Project Name: DURAN & ALEXANDER ADDN

**CITY OF ALBUQUERQUE
PLANNING DEPARTMENT
July 23, 2014
DRB Comments**

RE: Block C, Duran & Alexander Addition

8. **Project# 1010103**
14DRB-70196 MINOR - SDP FOR
BUILDING PERMIT
14DRB-70252 MINOR - PRELIMINARY/
FINAL PLAT APPROVAL

ANTHEA 4TH AND GRANITE  
 950 4TH STREET - SITE PLAN  
 ALBUQUERQUE, NM  
 PROJECT #388

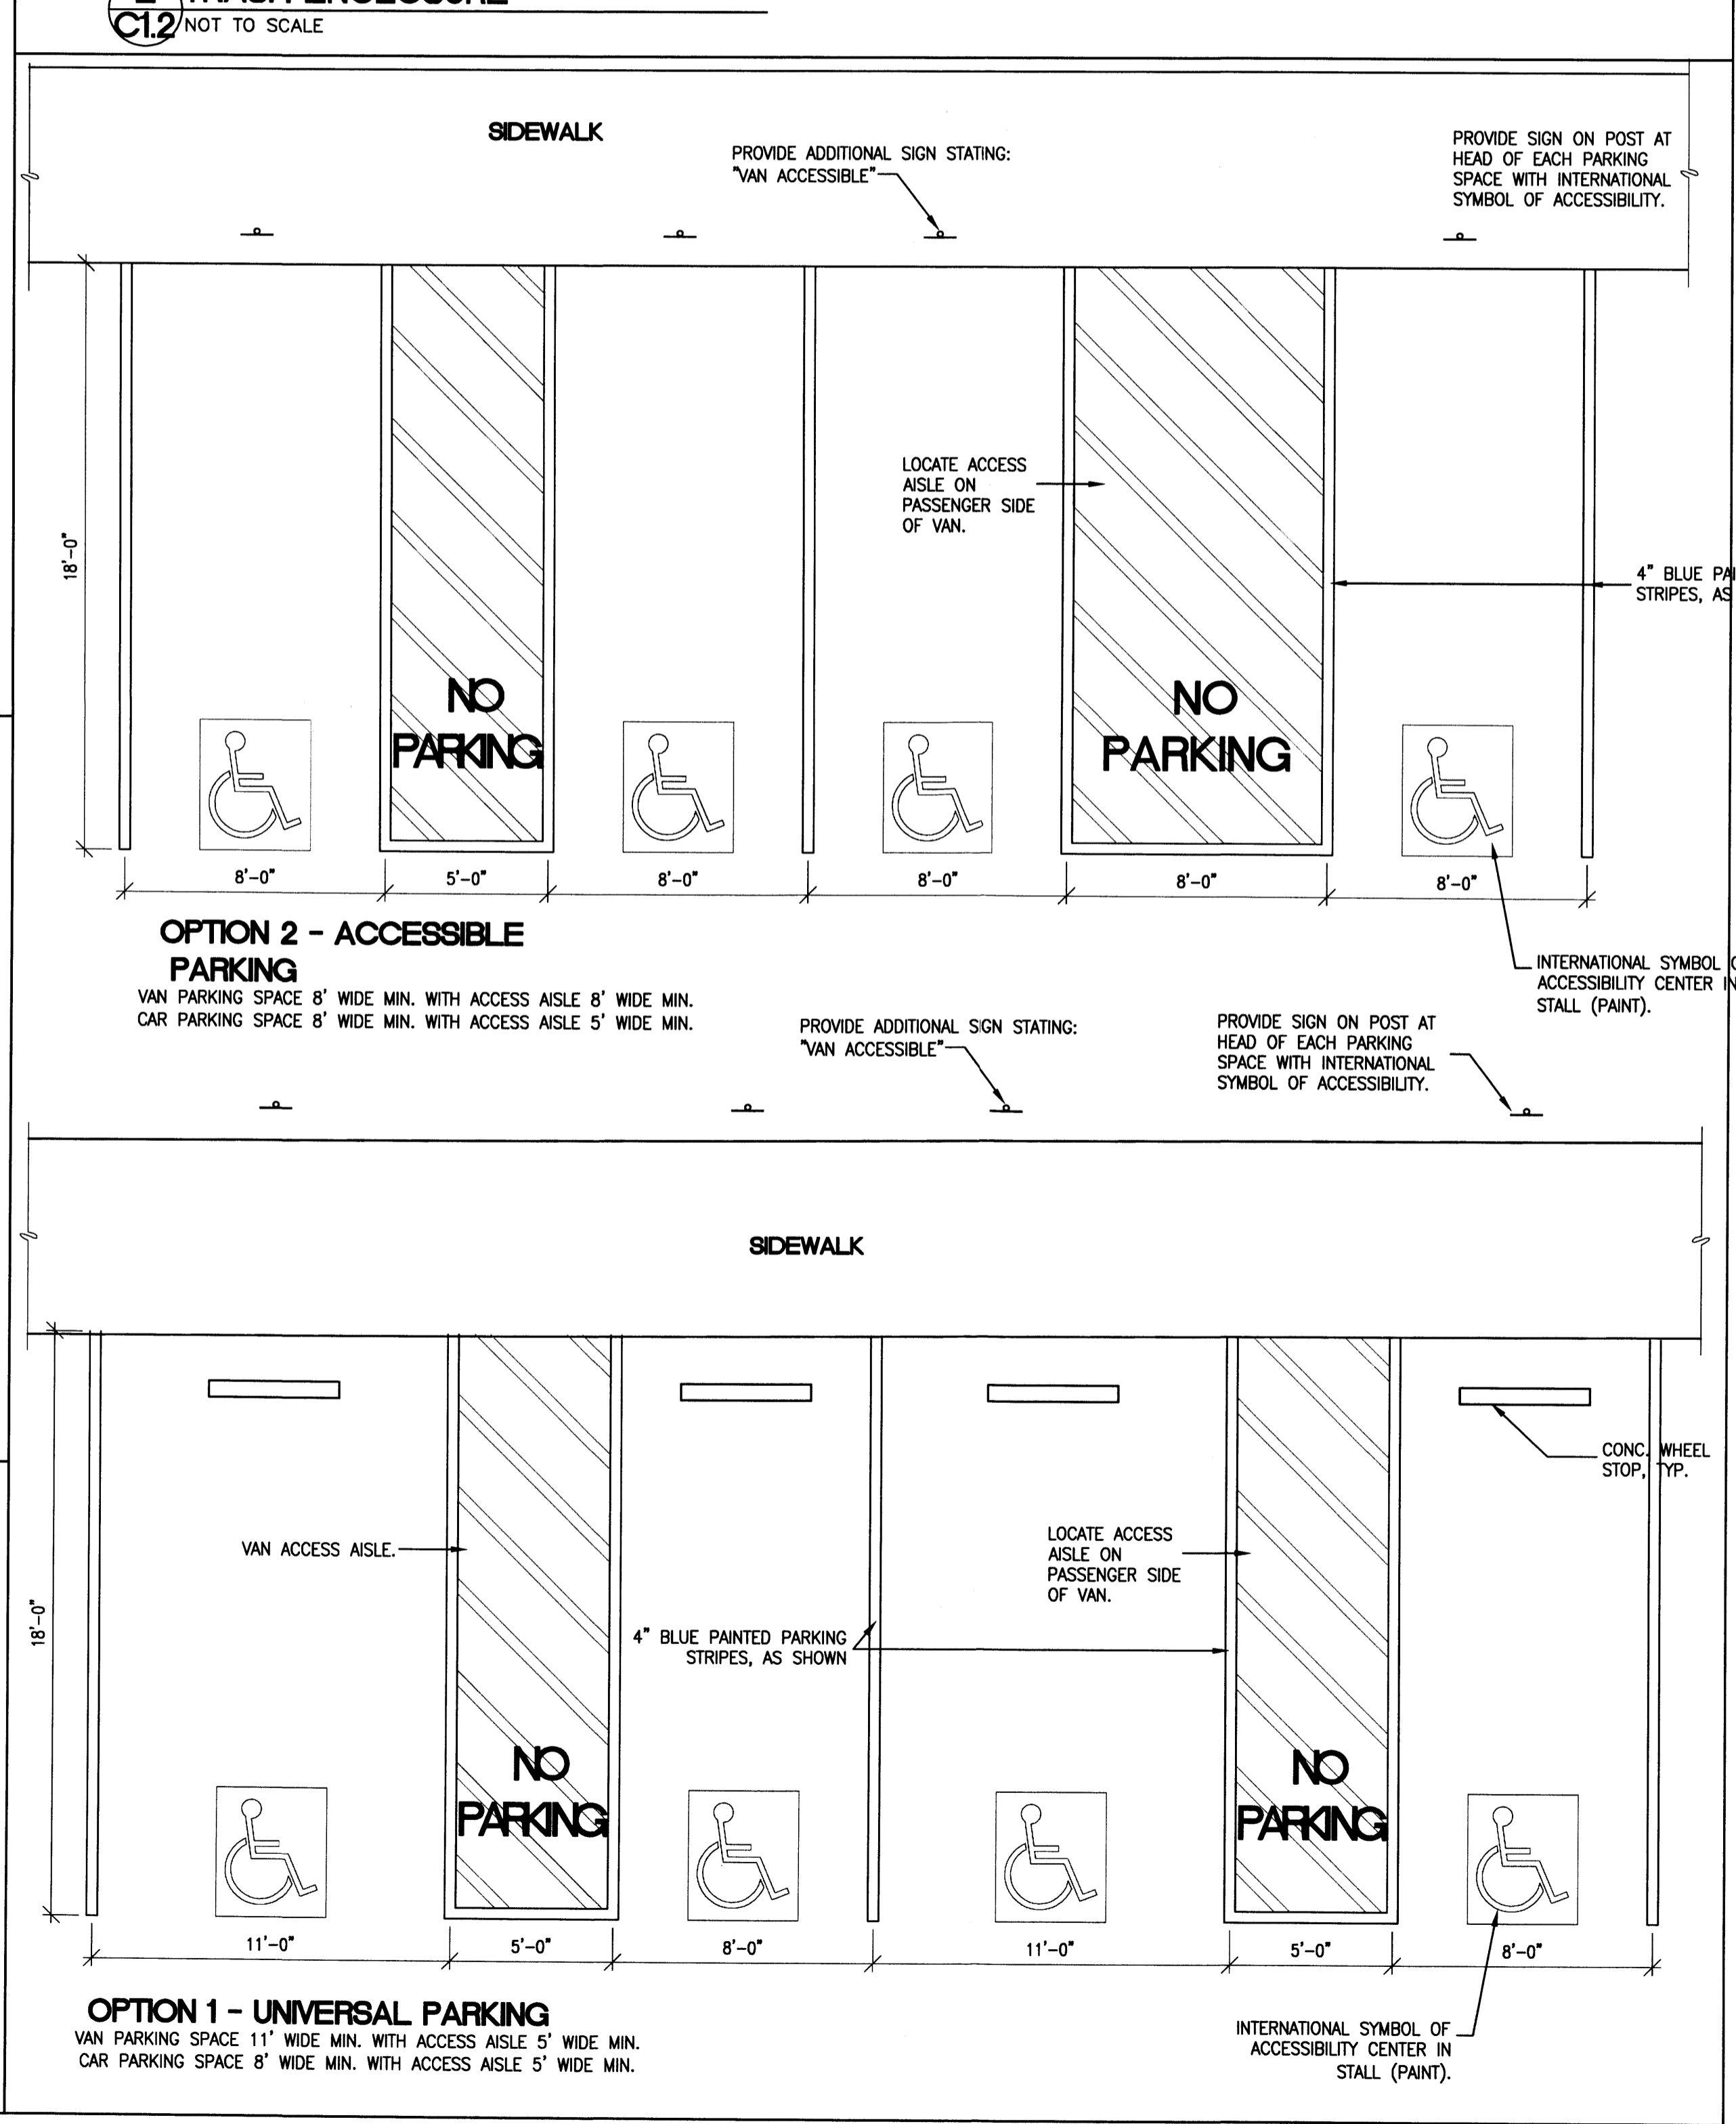
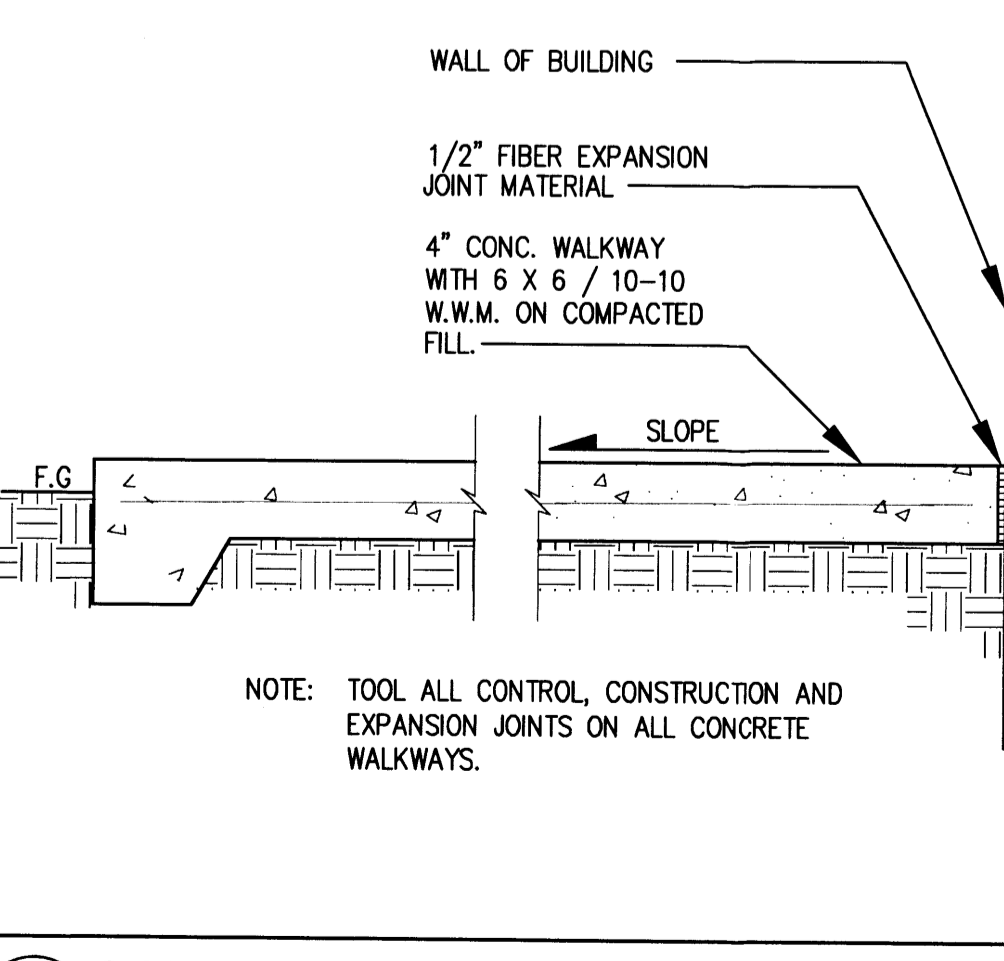
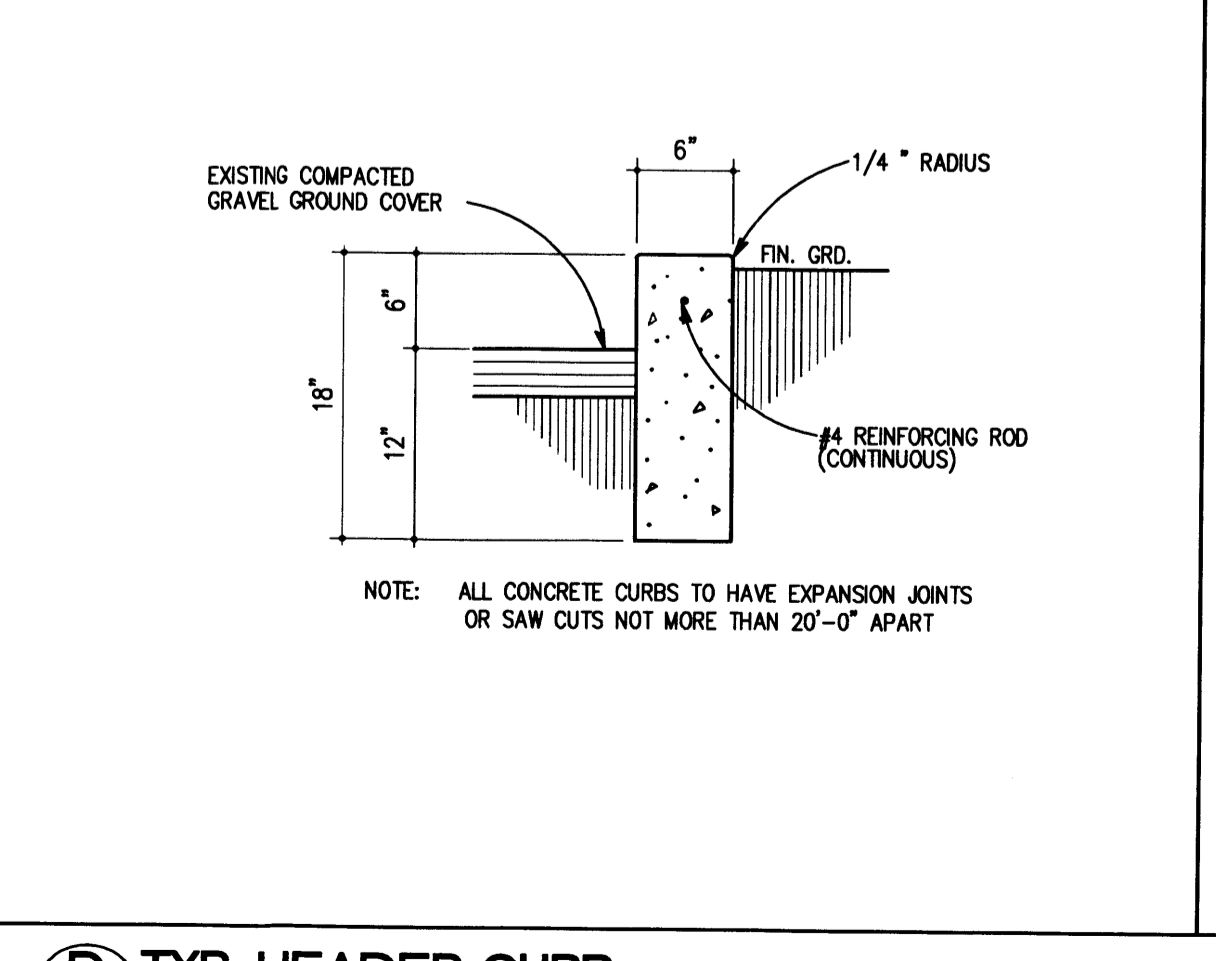
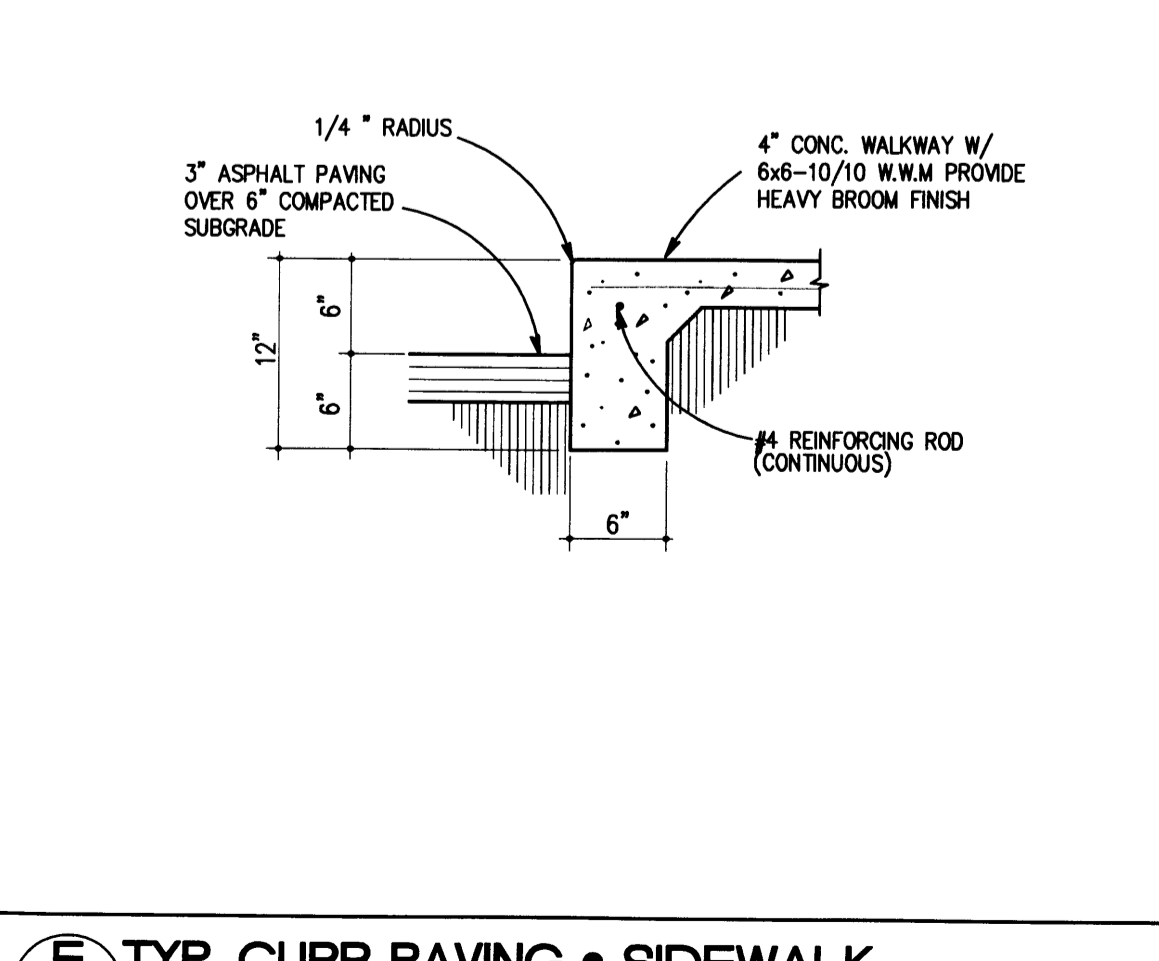
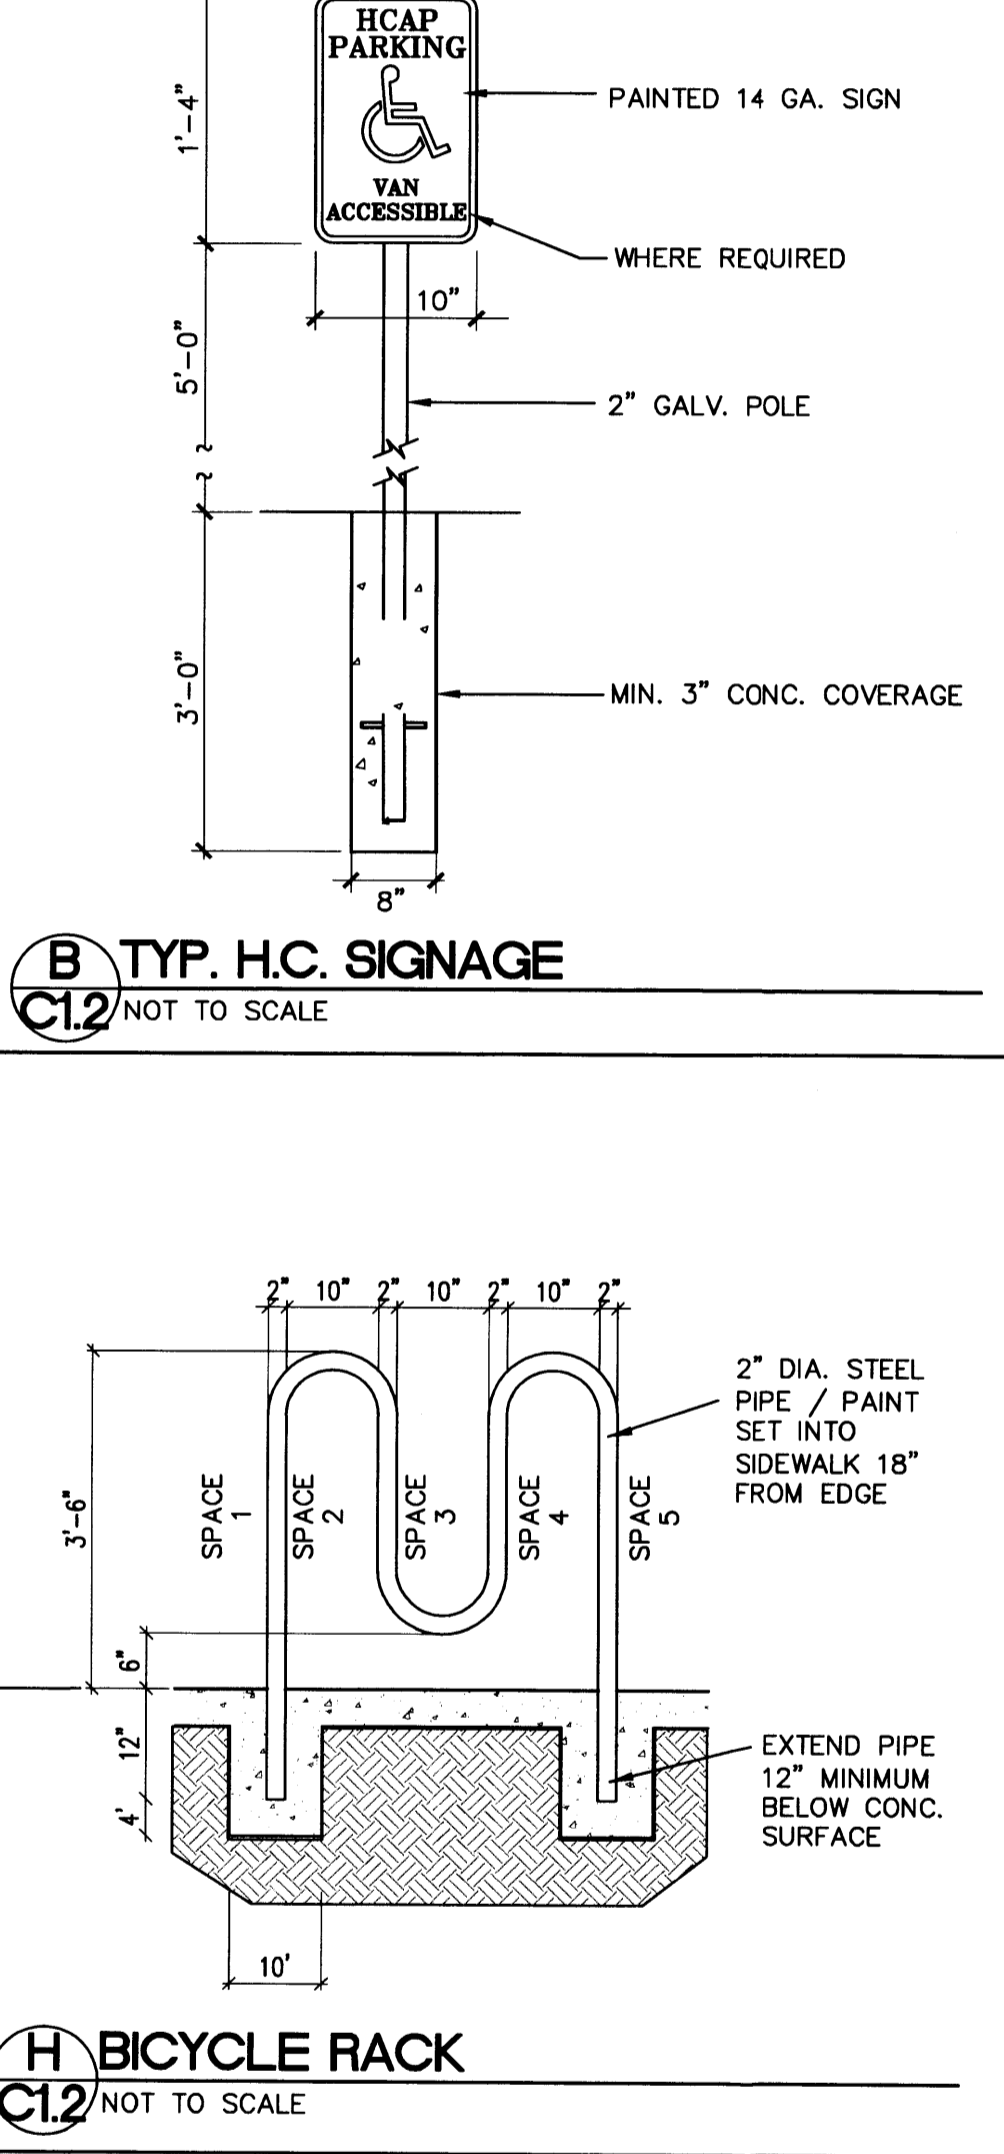
Please correct the calculation in the Parking Table; additionally, there are two parking spaces number 28.
